City of Portland, Maine - Building or Use Permit Application
389 Congress Street, 04101 Tel: (207) 874-8703, Fax: (207) 874-8716

Permit No: 02-0475 Issue Date: JUL - 2 2002 CBL: 116 C012001

Location of Construction: 30 Pitt St	Owner Name: Broche Gabrielle	Owner Address: 30 Pitt St	Phone: 207-828-1023
Business Name:	Contractor Name: allison carpentry	Contractor Address: 58 Osborne Avenue So. Portland	Phone: 2078381024
Lessee/Buyer's Name	Phone:	Permit Type: Additions - Multi Family	Zone: R-5

Past Use: 2 Family	Proposed Use: 2 Family	Permit Fee: \$429.00	Cost of Work: \$57,400.00	CEO District: 2
Proposed Project Description: 18 x 22 addition to 1 floor unit.		FIRE DEPT: <input type="checkbox"/> Approved <input type="checkbox"/> Denied	INSPECTION: Use Group: R-3 Type: SB BOCA 1999	
		Signature:	Signature:	
PEDESTRIAN ACTIVITIES DISTRICT (P.A.D.)				
Action: <input type="checkbox"/> Approved <input type="checkbox"/> Approved w/Conditions <input type="checkbox"/> Denied				
Signature: _____ Date: _____

DECK REVISIONS

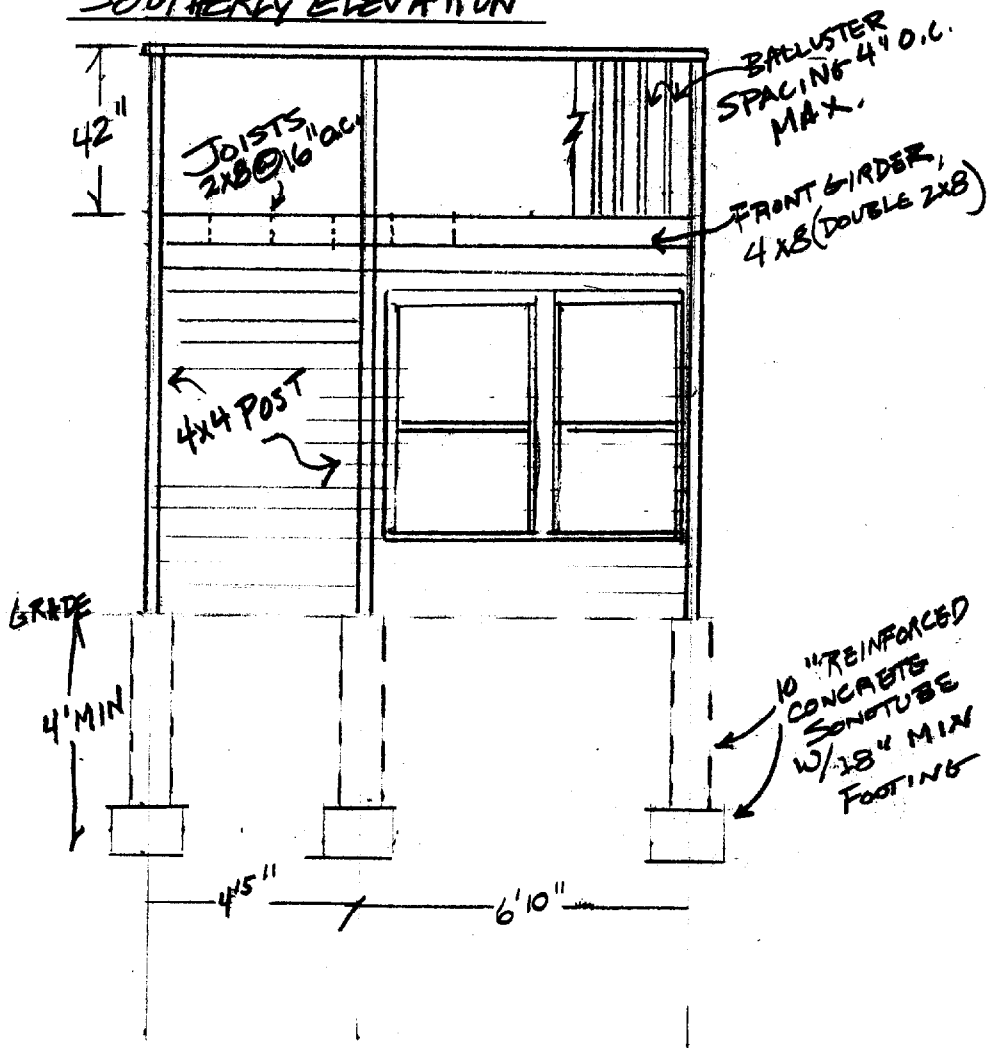
The open exterior stairway above the ground level has been removed from the project. Such open, exterior stairways above the ground floor are not allowed by ordinance.

ADDRESS: 30 Pitt Street, Portland, Maine

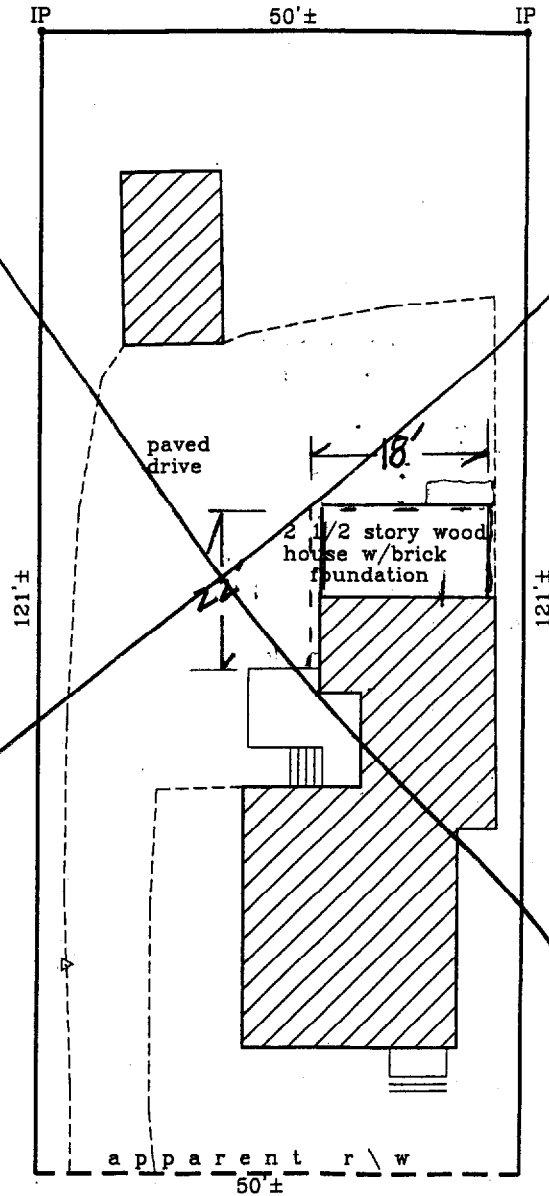
Comments: 30 Pitt St - 5/31/02 - plot plan not scalable and no setbacks shown - no stairway shown - no open outside stairway allowed - shows a "future kitchen" which can not be done. Left voice mail with owner to resubmit info. 6/5/02 met with owner & she resubmitted plans showing

*See revised
plan
DATE
6/5/02*

Plan of Future Kitchen

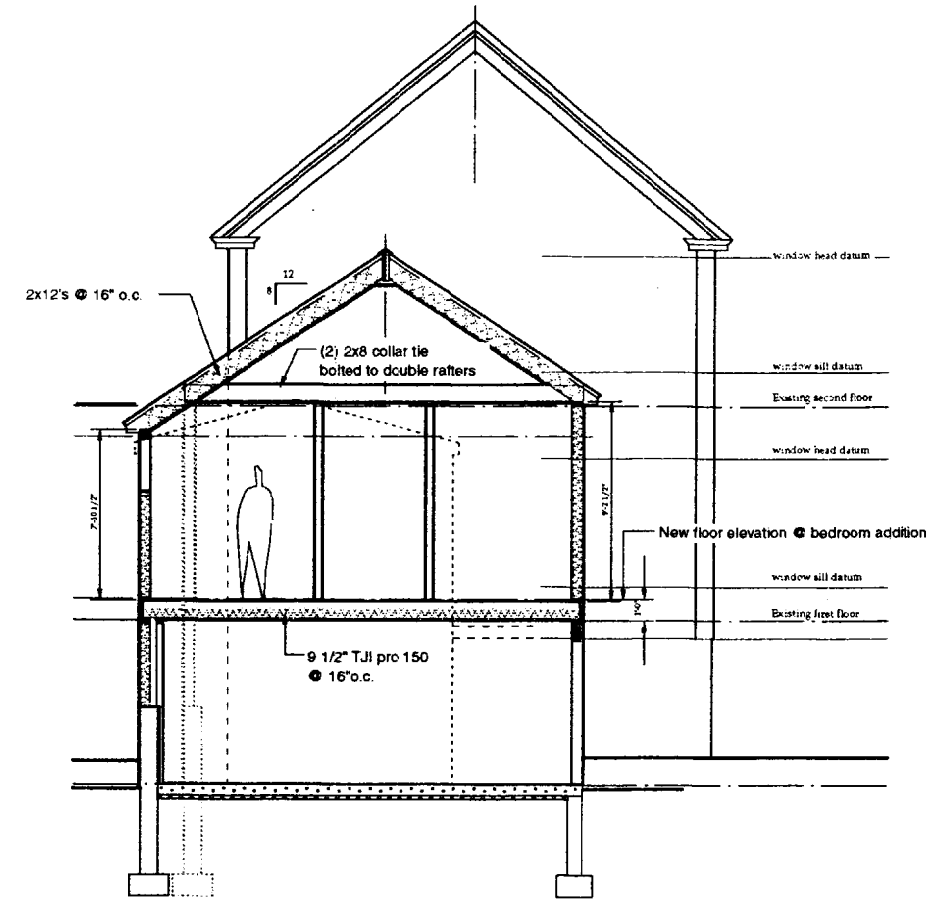
This is NOT an approval for an additional dwelling unit. You SHALL NOT add any additional kitchen equipment including, but not limited to items such as stoves, microwaves, refrigerators, or kitchen sinks, etc. Without special approvals. You may not wire up nor plumb up for any "future kitchen".
